Attachment B - Response to the Government Architect's Office Response

5 ELEVATION Lime Street Shopfront - Type E
1:50

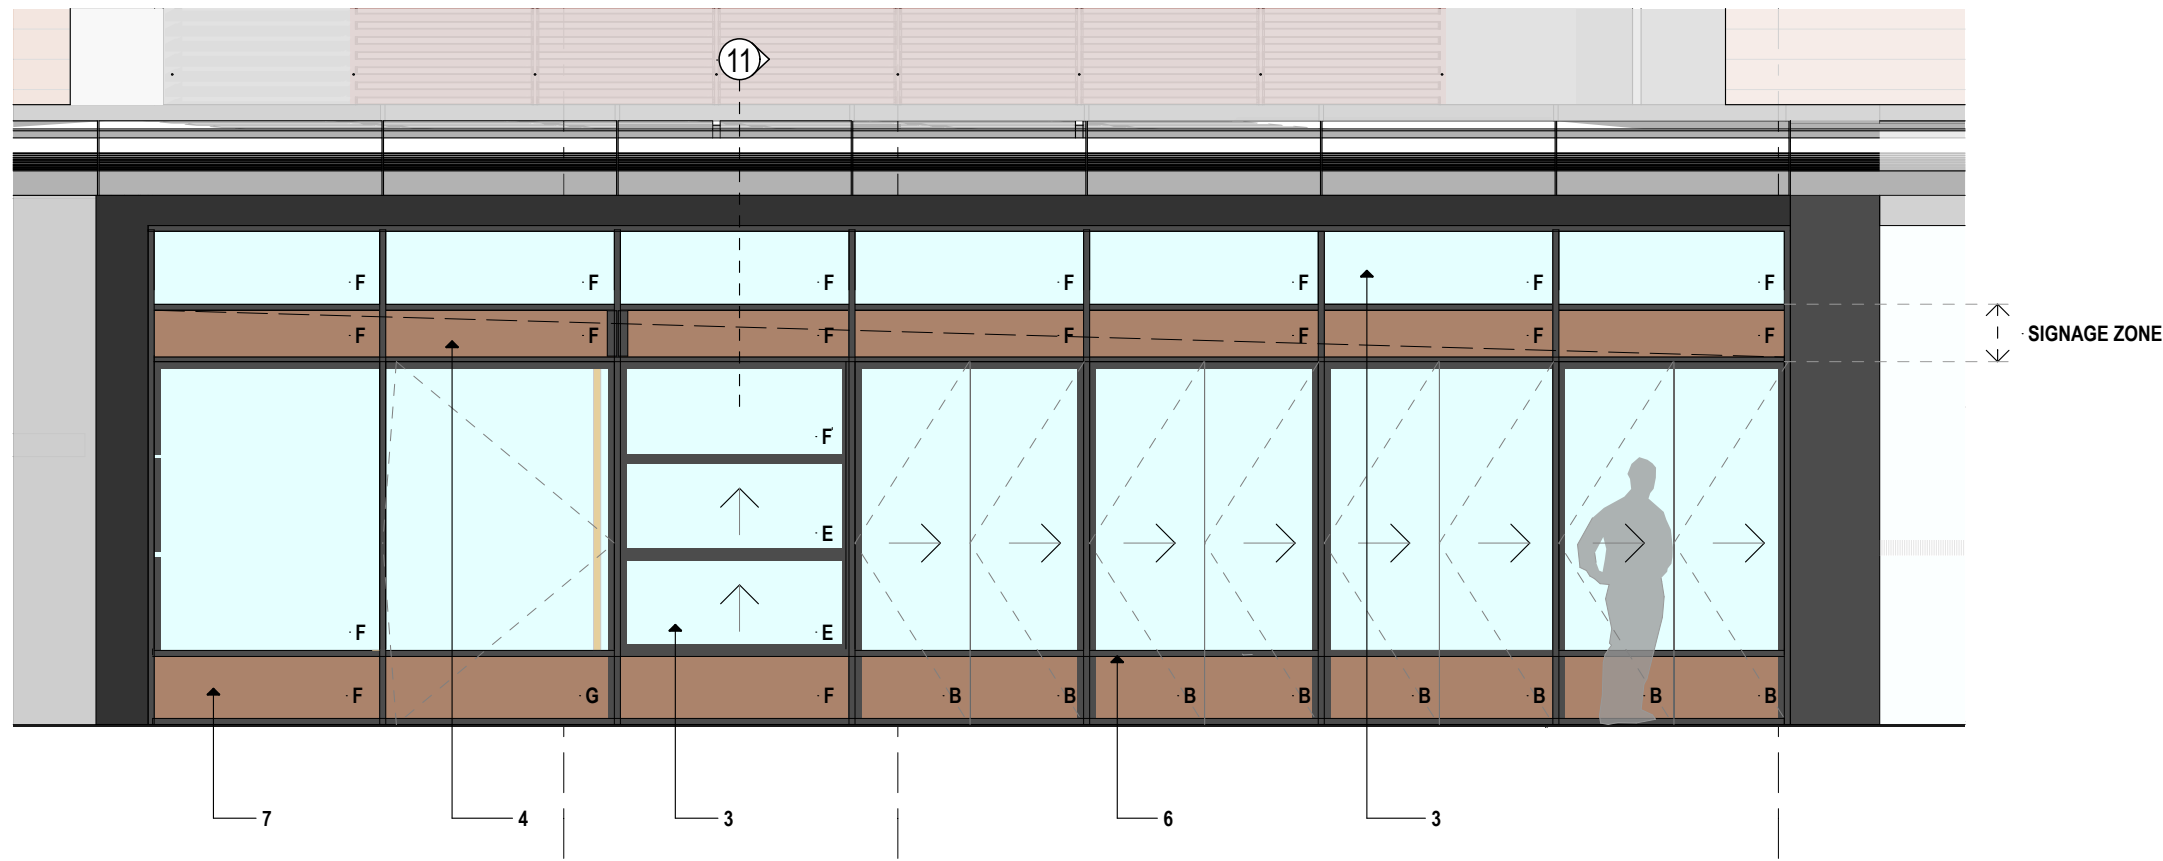
| Government Architect's Office Comment | Applicant Response |
|---|---|
| <p>The overall design intent for the shop fronts to Lime Street, including the method for the selection of shopfront types is not clear. Six options are provided for R8. A minimum or maximum number of shop front types would clarify the design intent on this elevation.</p> | <p>See response above.</p> |
| <p>A drainage solution is not shown from the box gutter of the non-continuous fixed awning.</p> | <p>This detail forms part of the detailed awning designs which have since been submitted and approved separately by the then Director-General.</p> |

| Government Architect's Office Comment | Applicant Response |
|--|--|
| <p>The method of selection of shop front design to Lime Street (R8 and R9) has not been provided, however is likely to be supported (refer items requiring clarifications below).</p> | <p>The method for selecting the shop front design will be determined by the future tenant of each respective tenancy. The design will be selected by the tenant according to their design and operational needs. The range of shopfronts presented have been prepared by the respective architects to be compatible with the relevant building.</p> |

GENERAL ARRANGEMENT PLAN
Level 8 Floor Plan

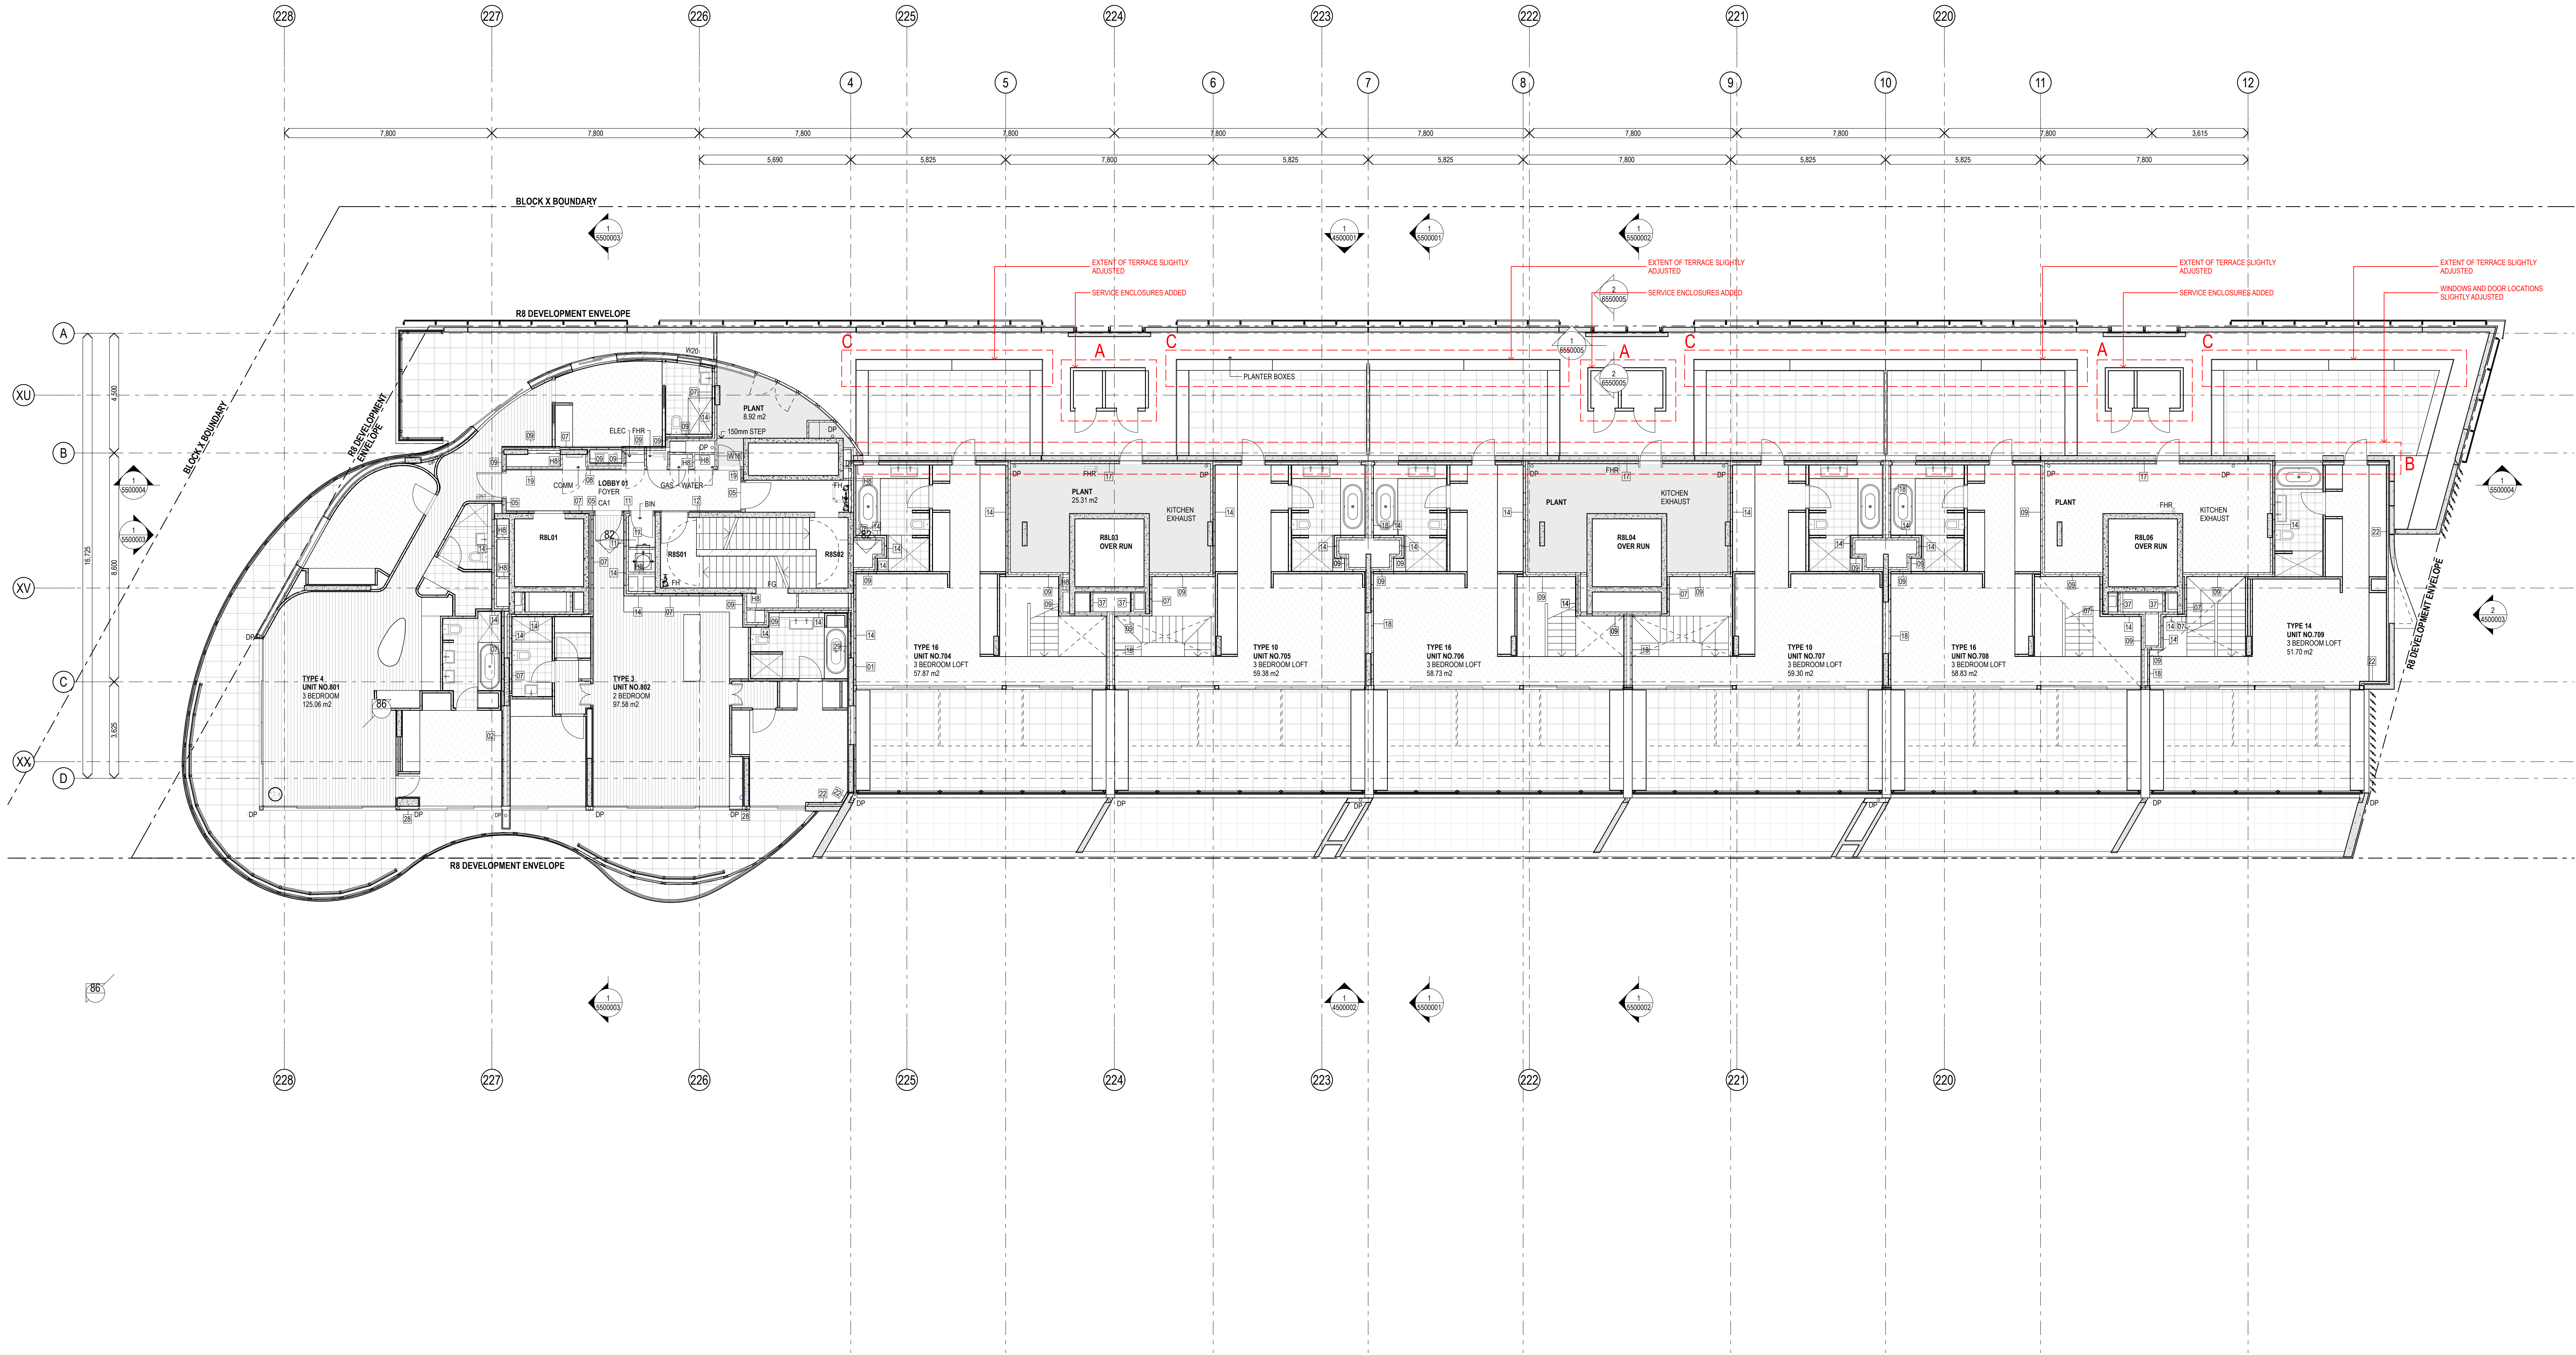
| Government Architect's Office Comment | Applicant Response |
|---|--|
| <p>The nature and impact of the service exhaust on level 8 (R8) is not clear, further clarification is required before an assessment can be made.</p> | <p>The service enclosures are specified as a result of further design development and will sit below the height of the parapet and will not be visible from the public domain. It is not considered that any further assessment is necessary.</p> |

| Government Architect's Office Comment | Applicant Response |
|---|---|
| <p>It is not clear if the housed service exhaust from the stair on level 8 (R8) is mechanically ventilated. While the noise report indicates no change, the environmental impacts (noise / air quality) on occupants of the building and associated terraces is not provided.</p> | <p>The 'housed service exhaust' is located above the fire stairs and is provided to allow heat to be exhausted from the stairs, which are naturally ventilated. As a result the exhaust will not have any noise or air quality impacts on the residential apartments.</p> |

GENERAL ARRANGEMENT PLAN				
Roof Plan				
Drawn By	Date	Purpose	Approved By	Date
QHS	15/04/14	STW	JP	
SCALE 1:100 @ B1 1:250 @ A3				
Site No.	Drawing No.	Revision		
BR8	BR8AD3110000-05

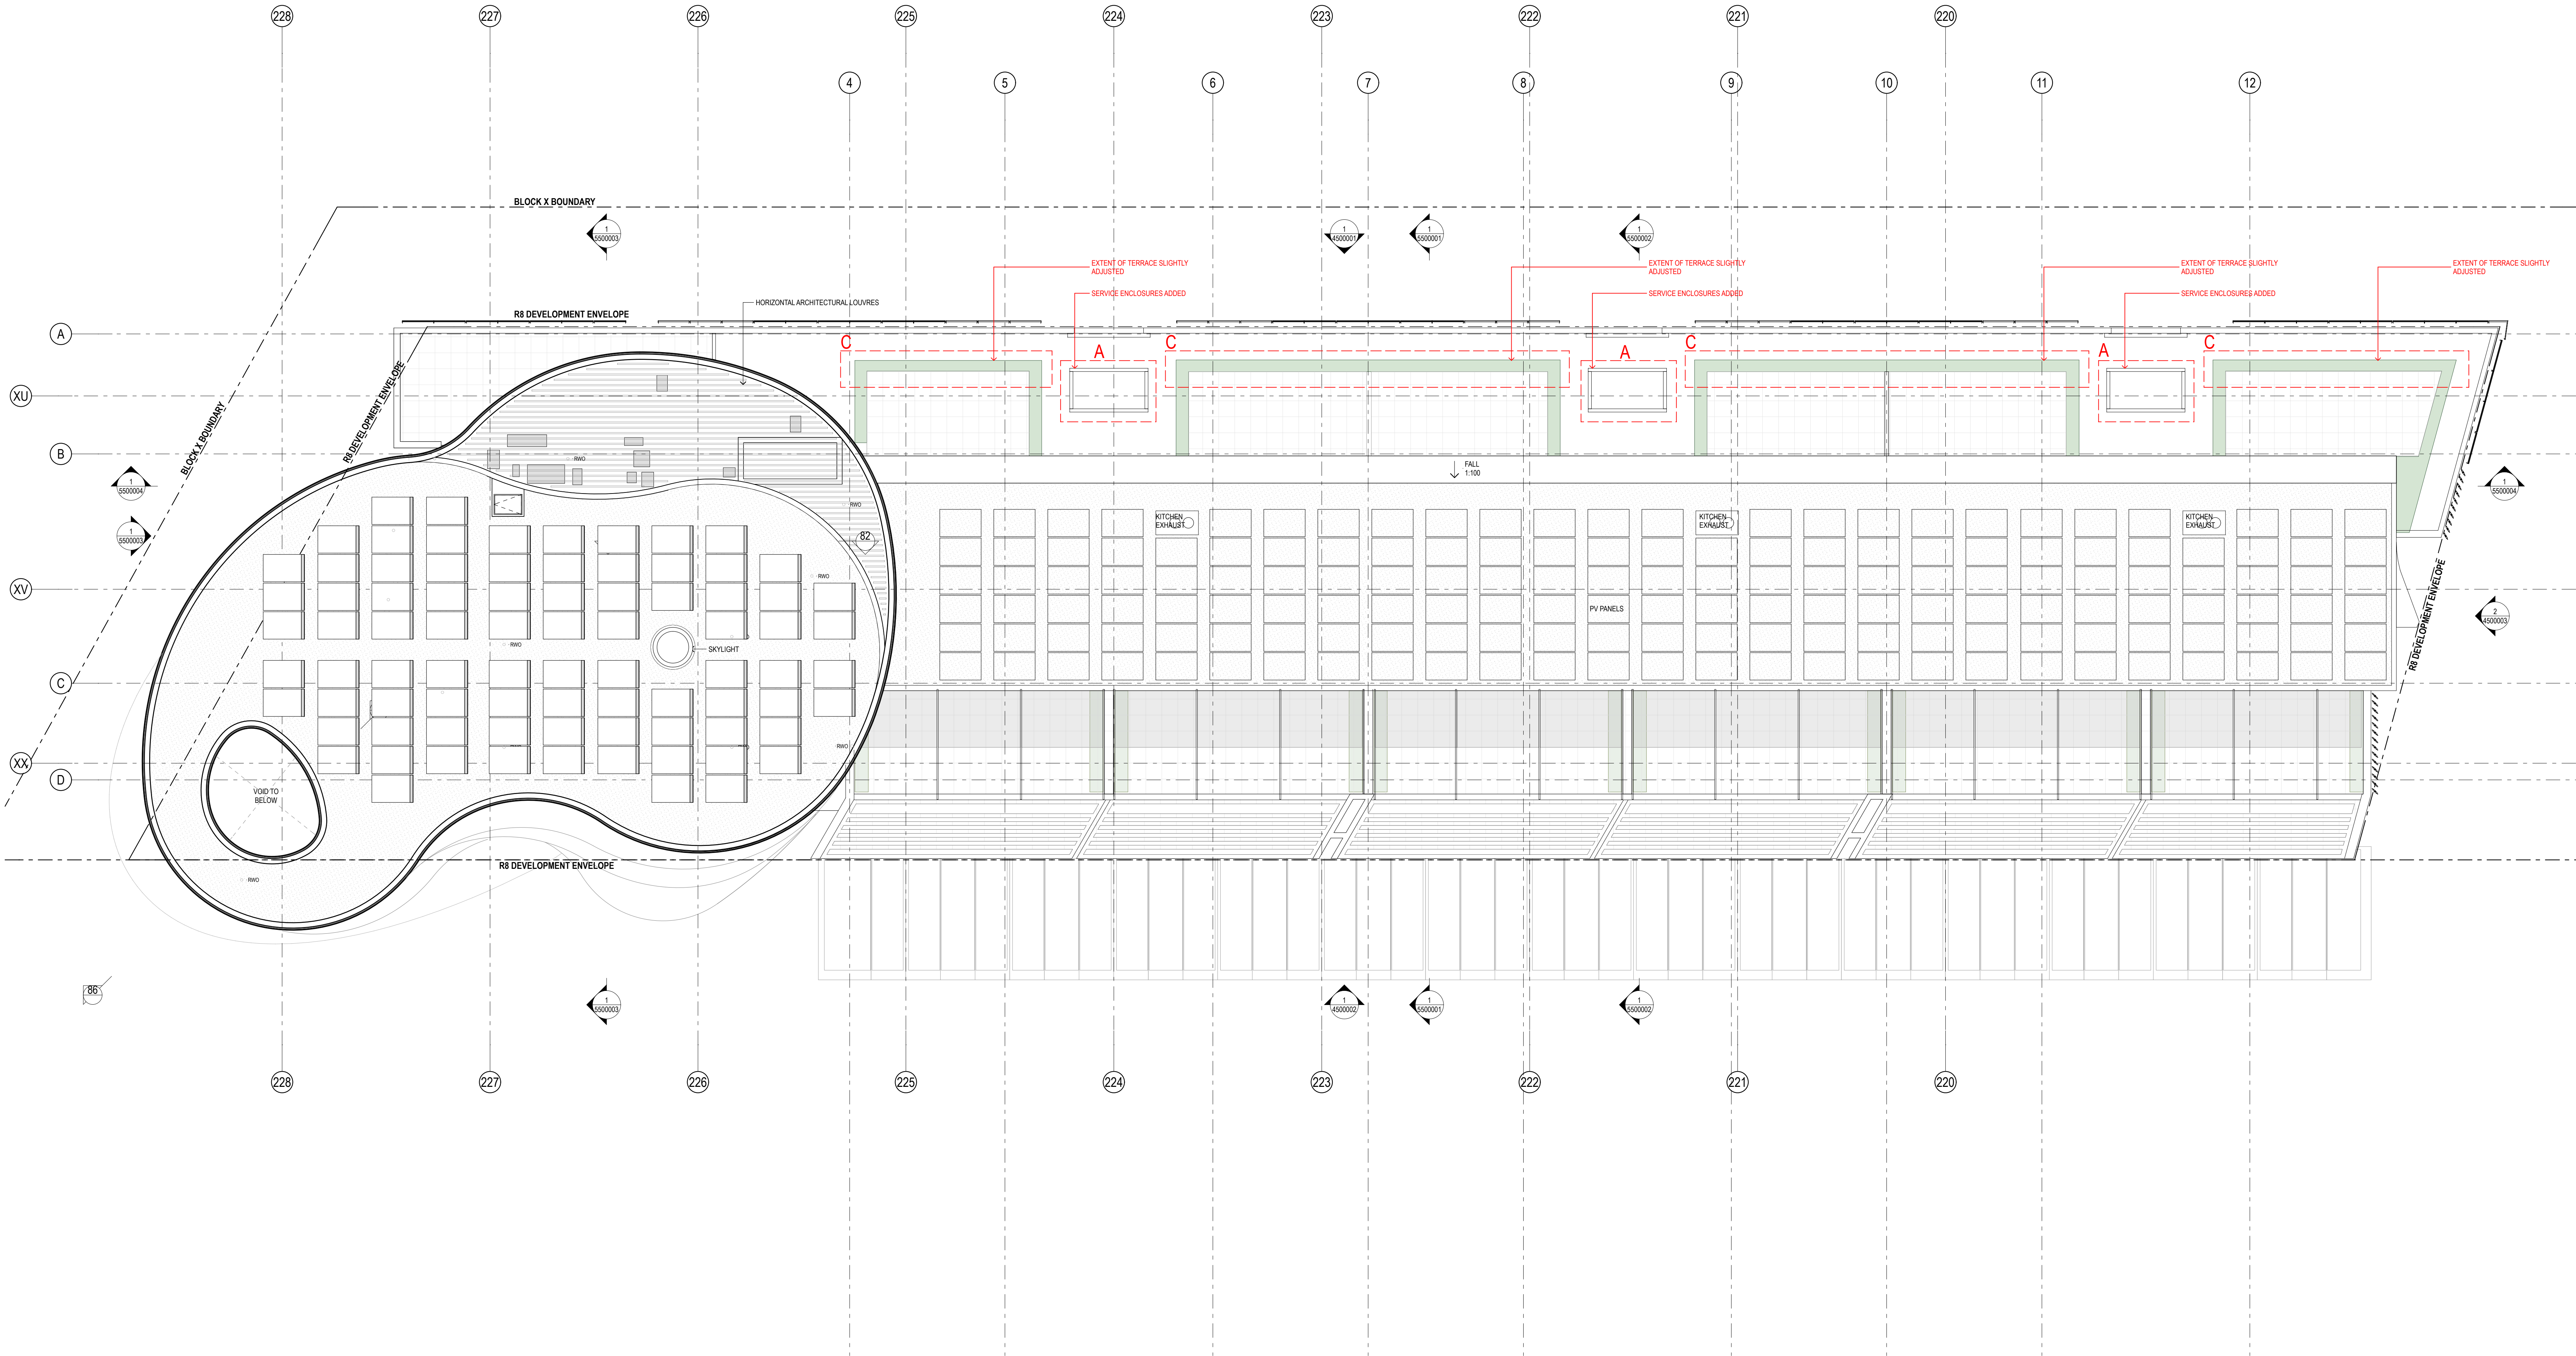
| Government Architect's Office Comment | Applicant Response |
|---|---|
| <p>The impact of the changed angle of the PV panels has not been adequately evaluated. The changed angle of the PV panels has not been represented on the elevations and reflectivity impacts have not been provided. Further, the extent of the breach of the Masterplan height limit by the panels (R8) is not shown on the drawings. A zone could be indicated on the roof plan.</p> | <p>See response above.</p> |
